Subject: FW: Planning Consultation on M/28/20/DOC

Engineers comments;

The level of detail supplied is currently insufficient to enable the discharge of conditions 11, 13 or 14.

Site: YAPTON POULTRY FARM
Project: MIDDLETON RESIDENTIAL
Date: 01/07/2020
Drawing: SITE VISIT DISCUSSION
APPENDIX 02

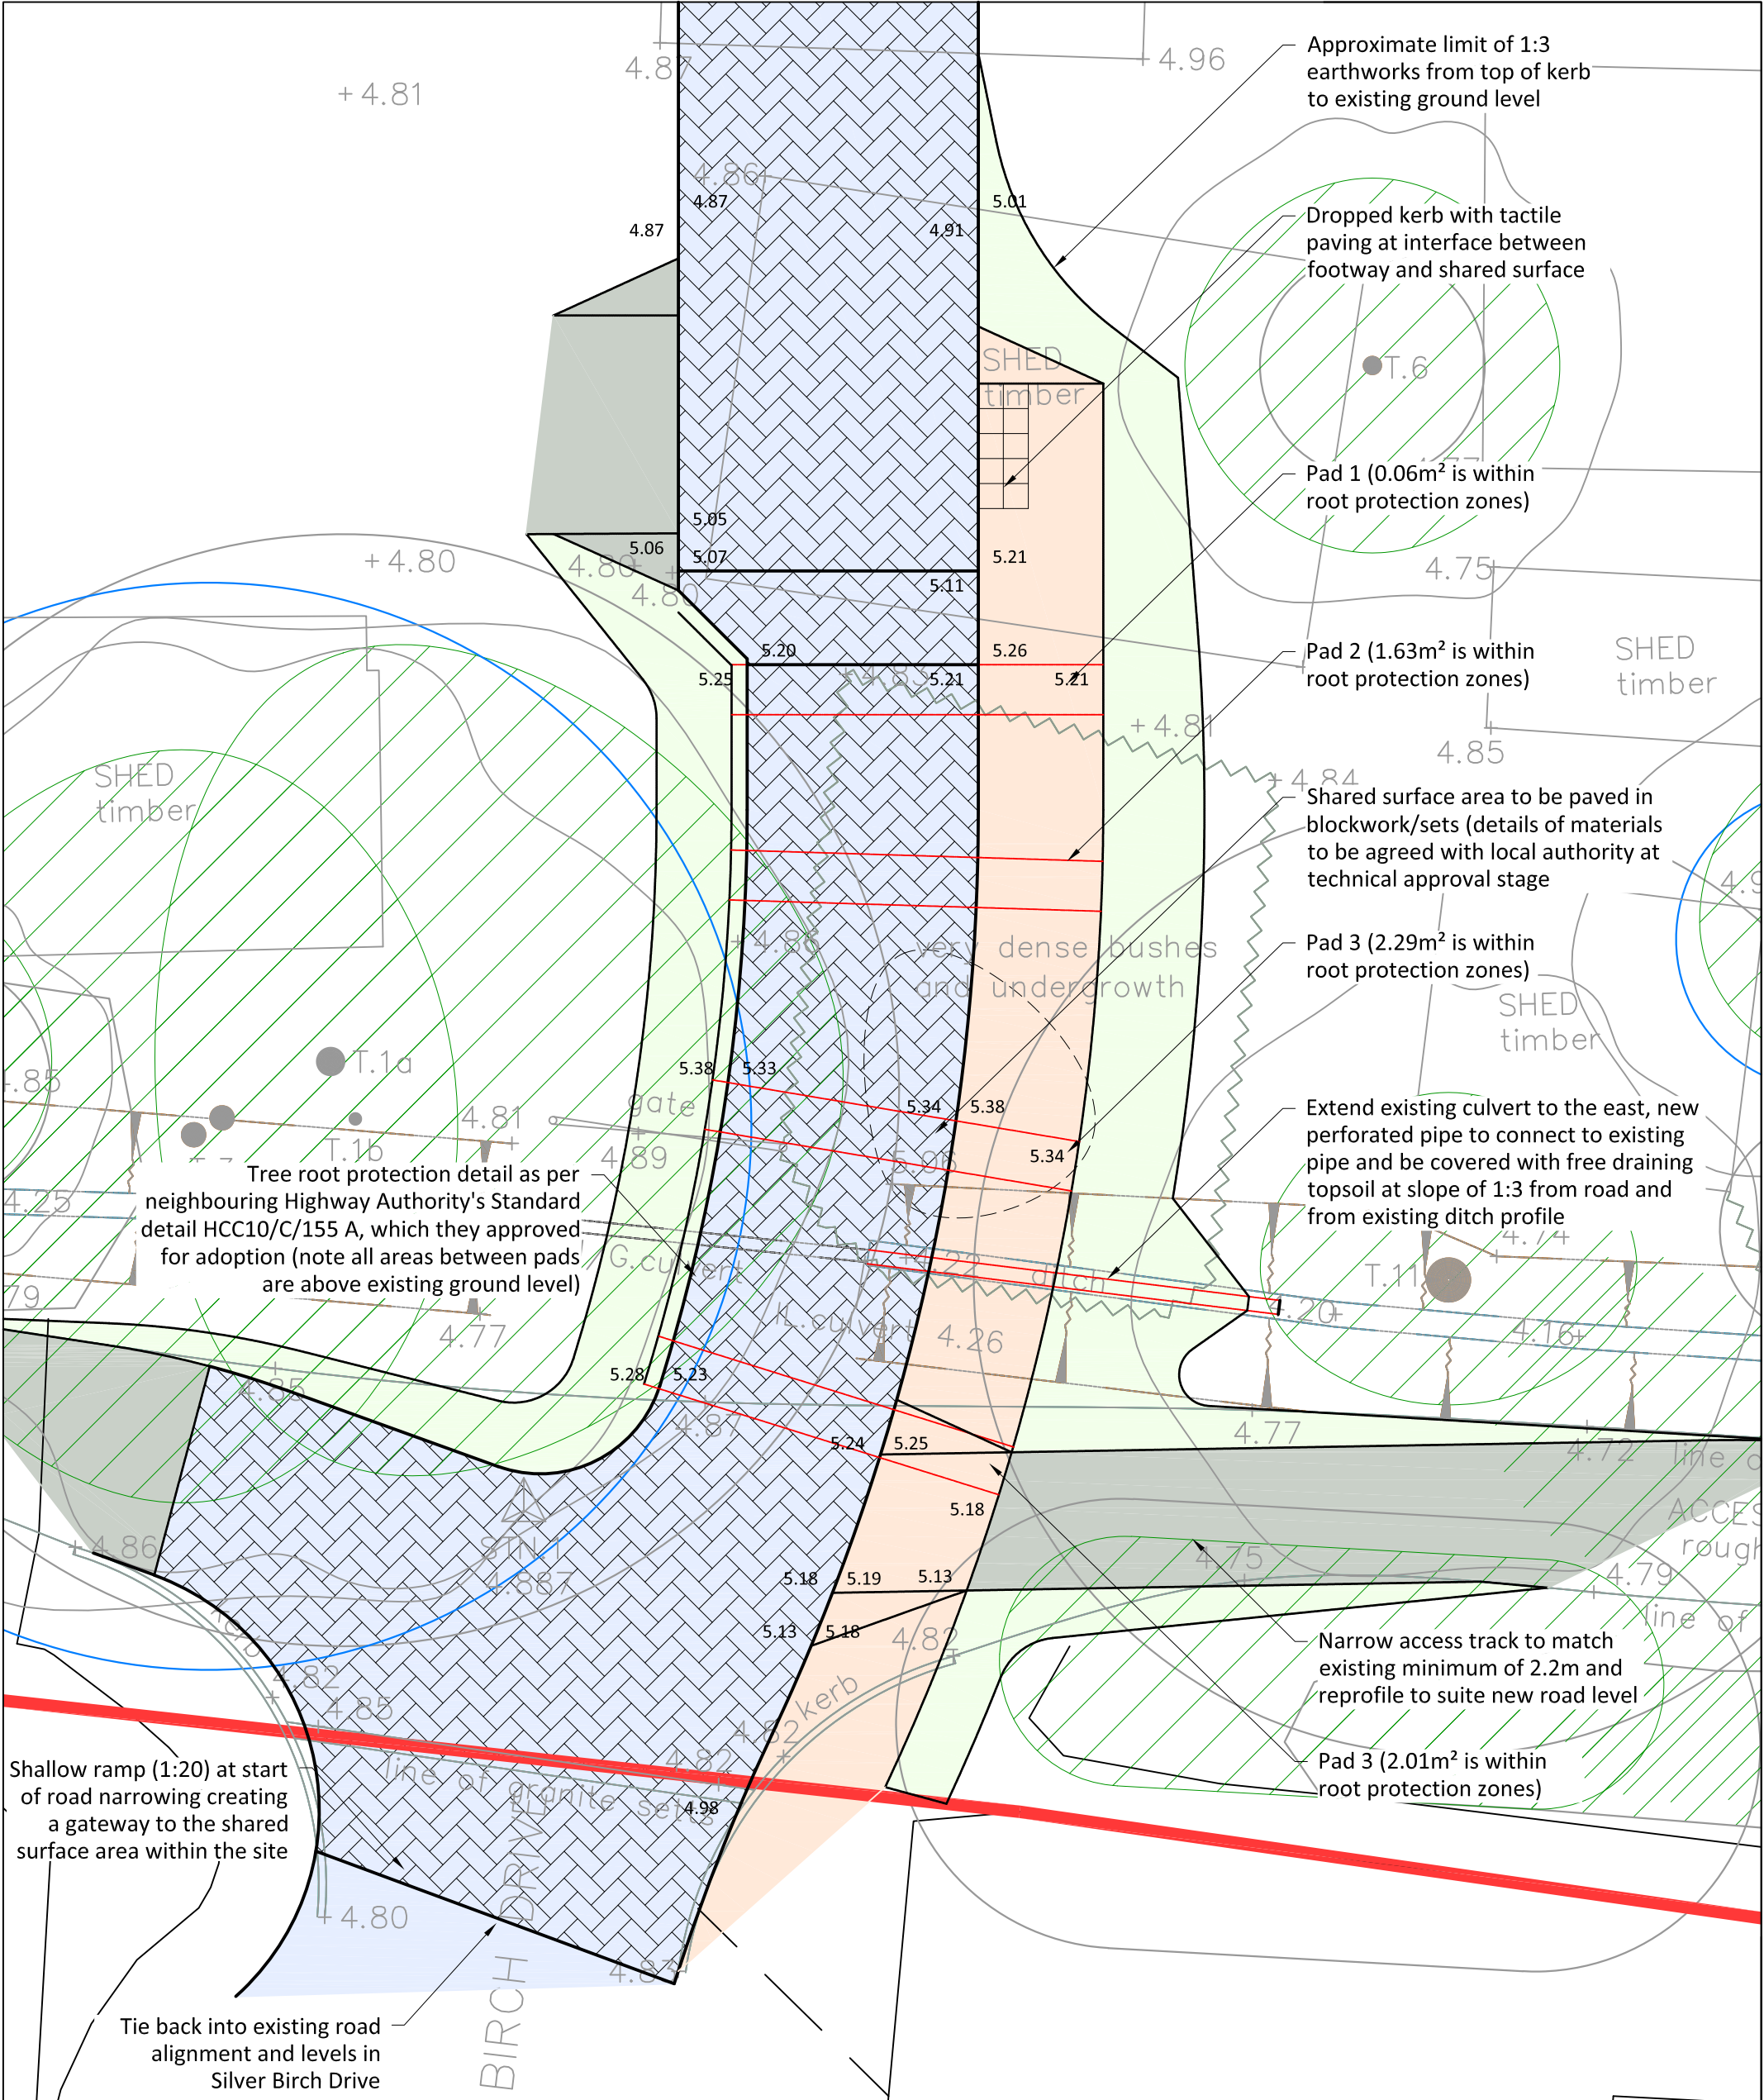
Regarding the ditches on the southern boundary, it is very likely that these will need improvements and I suggest a meeting takes place on site to look at these. Land Drainage Consent will be required for any alterations to them, including culverting and any discharge structures. This will all need to be fully detailed on the drawings.

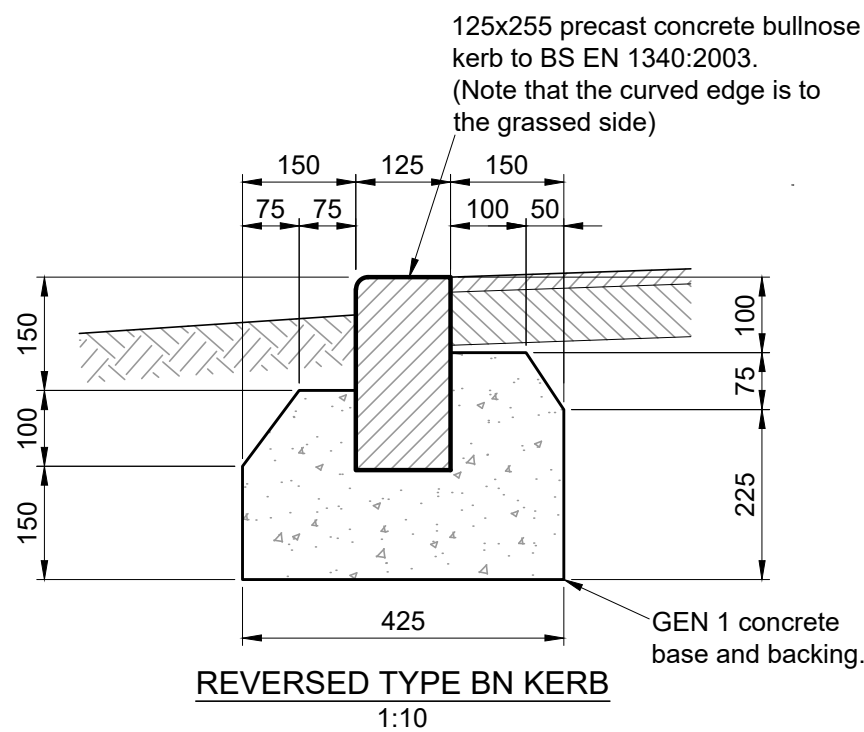
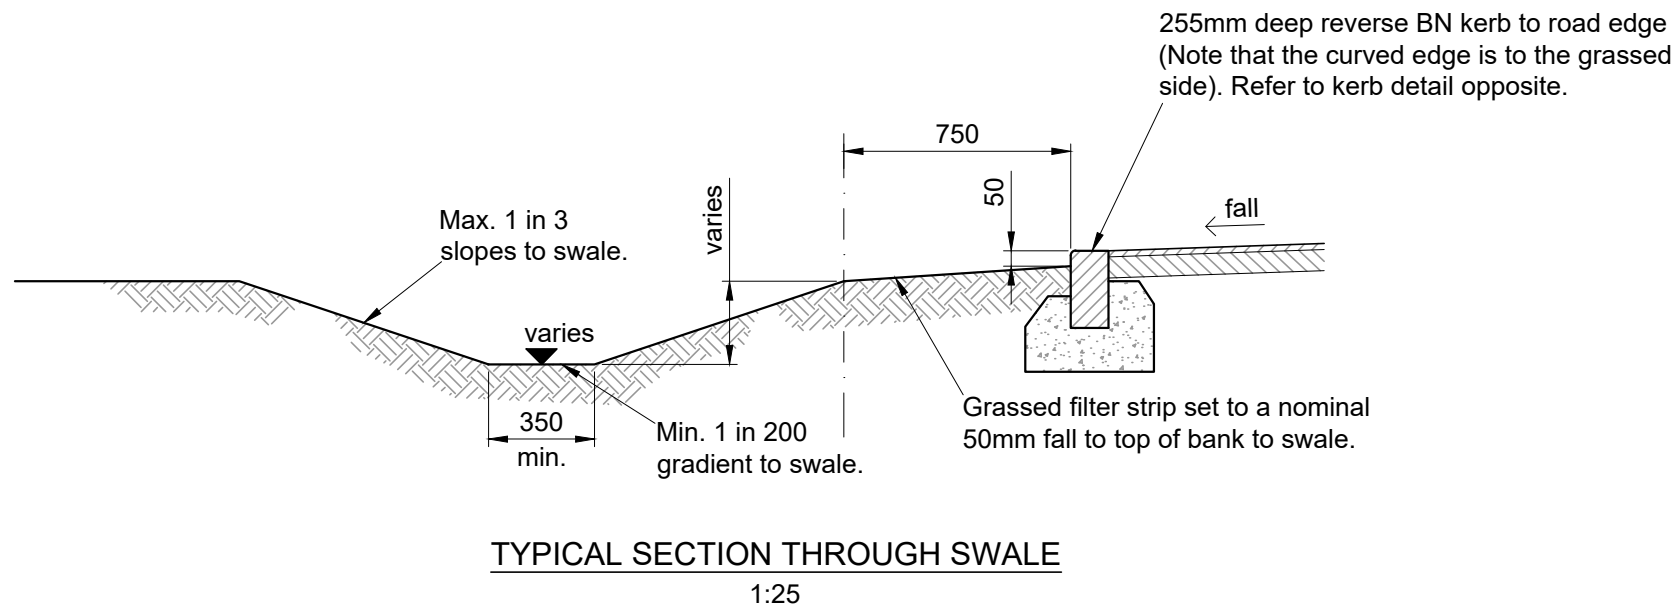
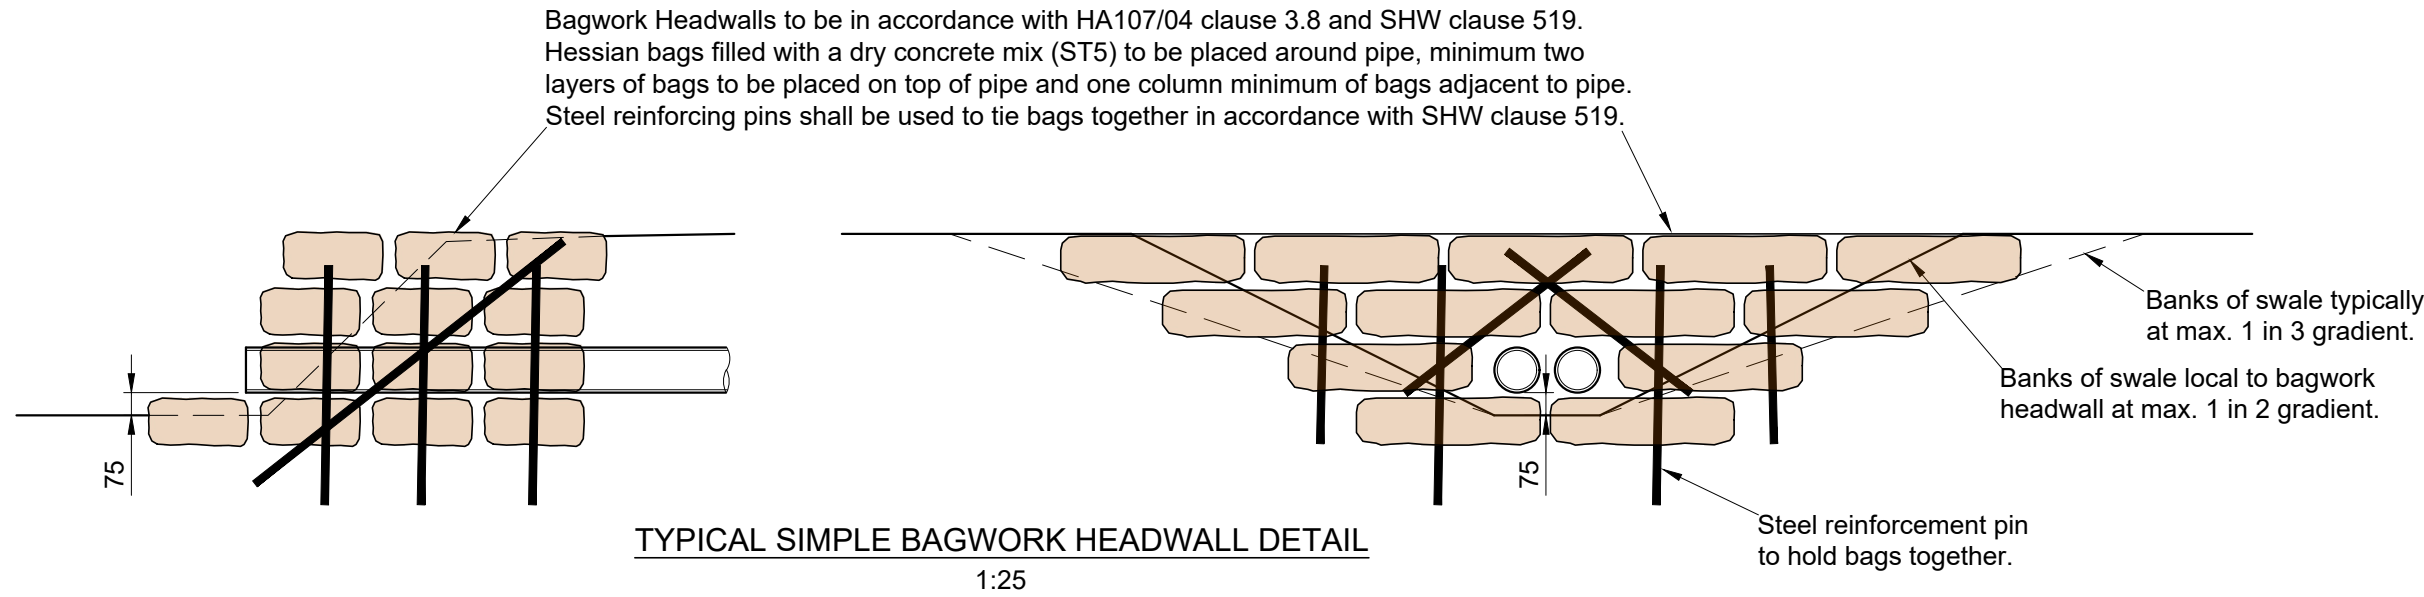
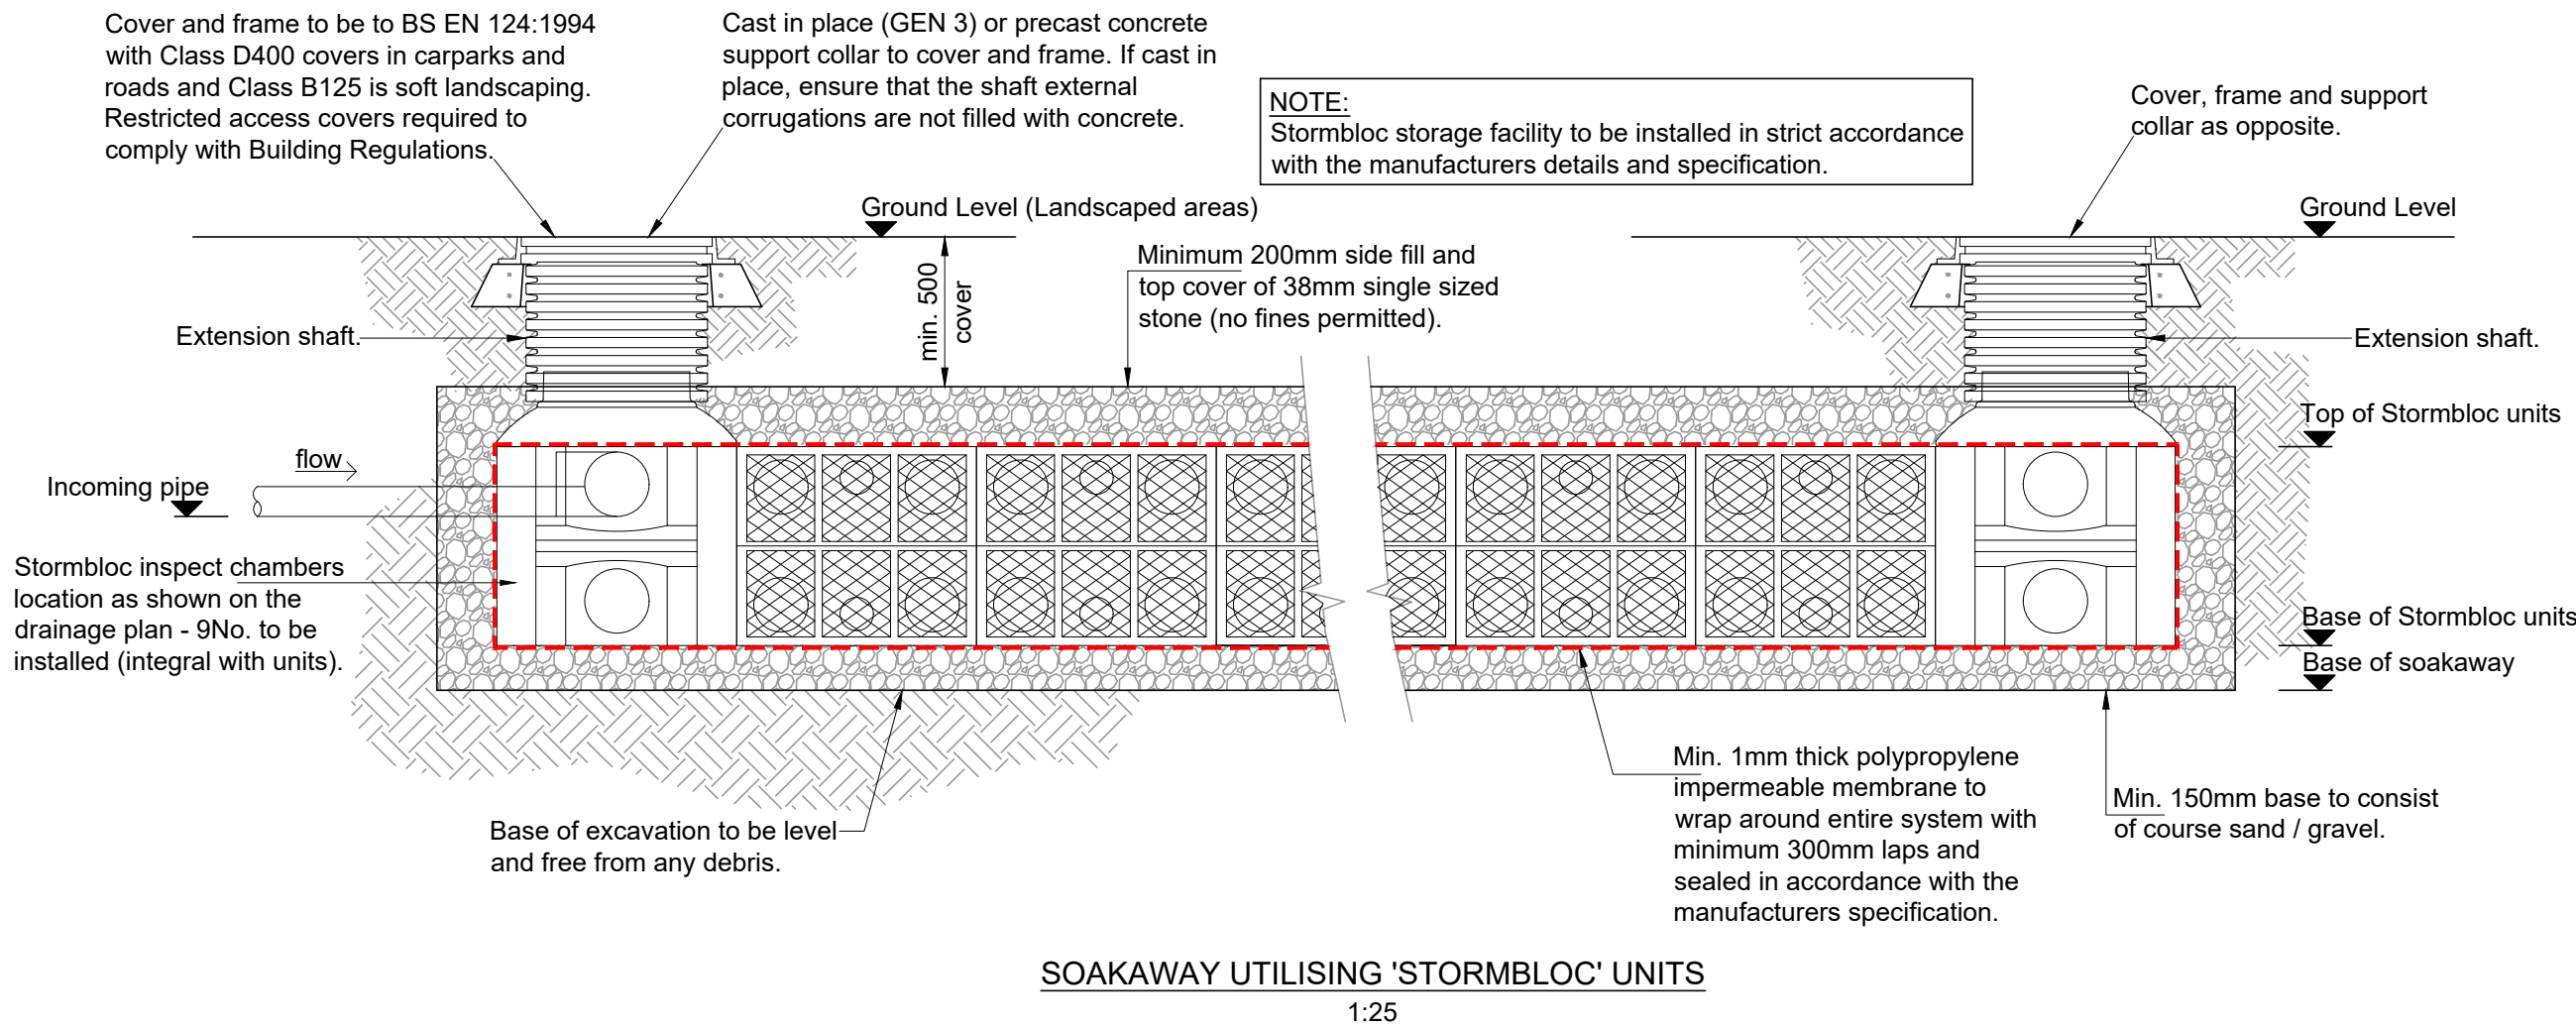
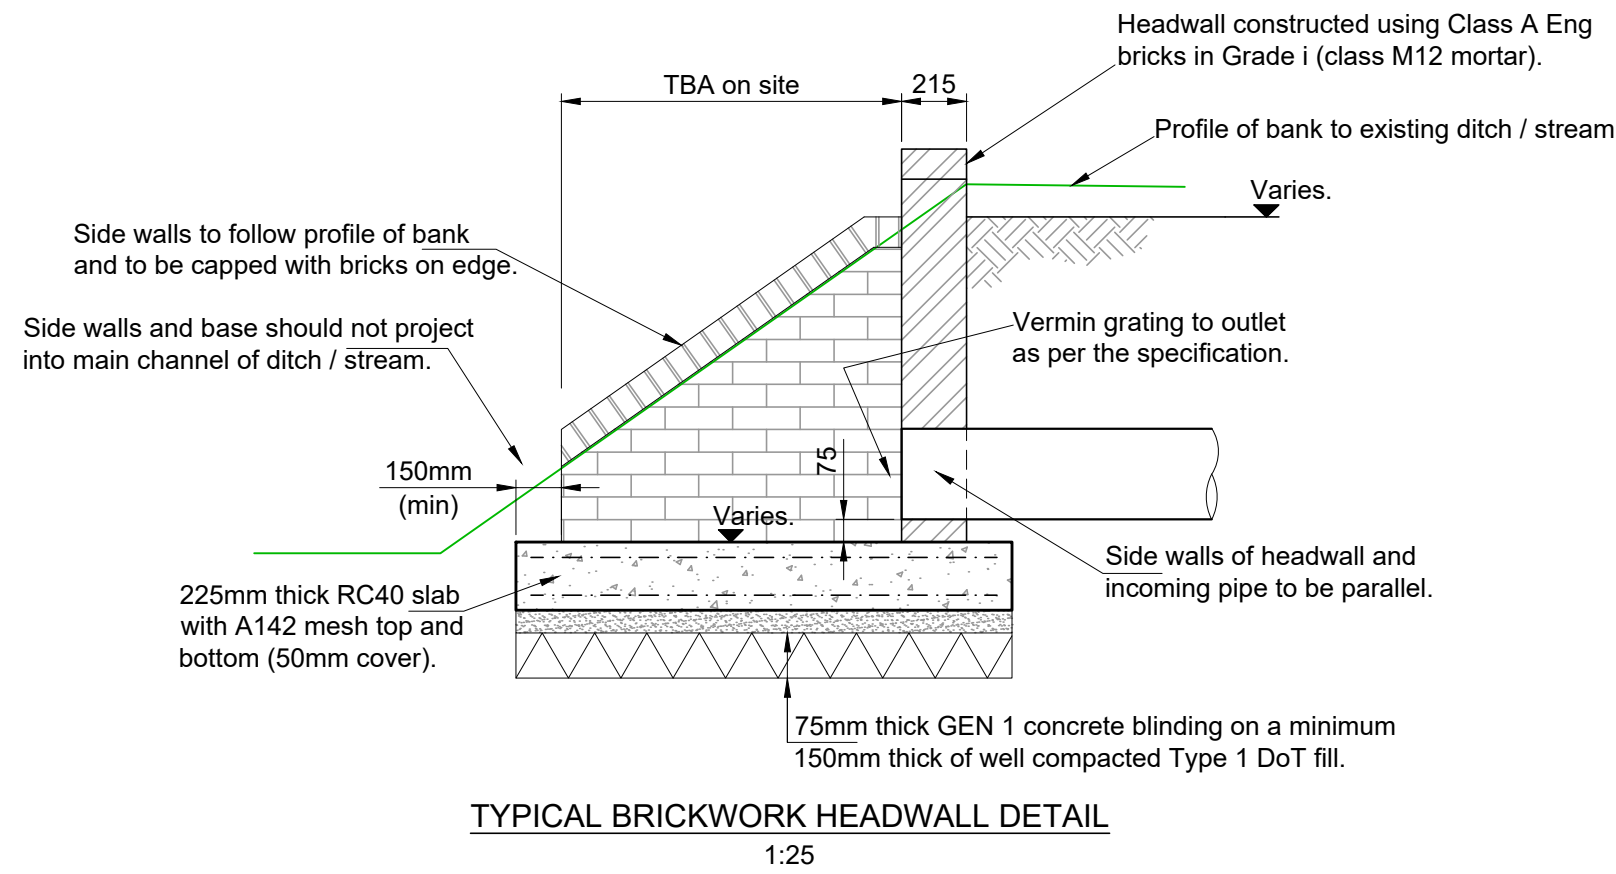
Once we have agreed the scheme principles, fully detailed plans will be required to include pipe/structure, cover levels/invert levels/base levels/diameters/gradients, etc, along with fully detailed construction drawings for all drainage elements. Please note that open suds features should be employed where possible. The current arrangement of crates is currently not desirable, since they have been arranged in manner as to use almost every

piece of available space outside the root protection zones (zones will need to be confirmed), rather than achieve a more practical layout whereby membranes can be wrapped around the crates in a more suitable manner ie. reduce the number of corners. Please note that our tree officer will need to be involved in discussions in this respect due to protect the trees and the crates. Permeable paving will need to be employed where ever possible.
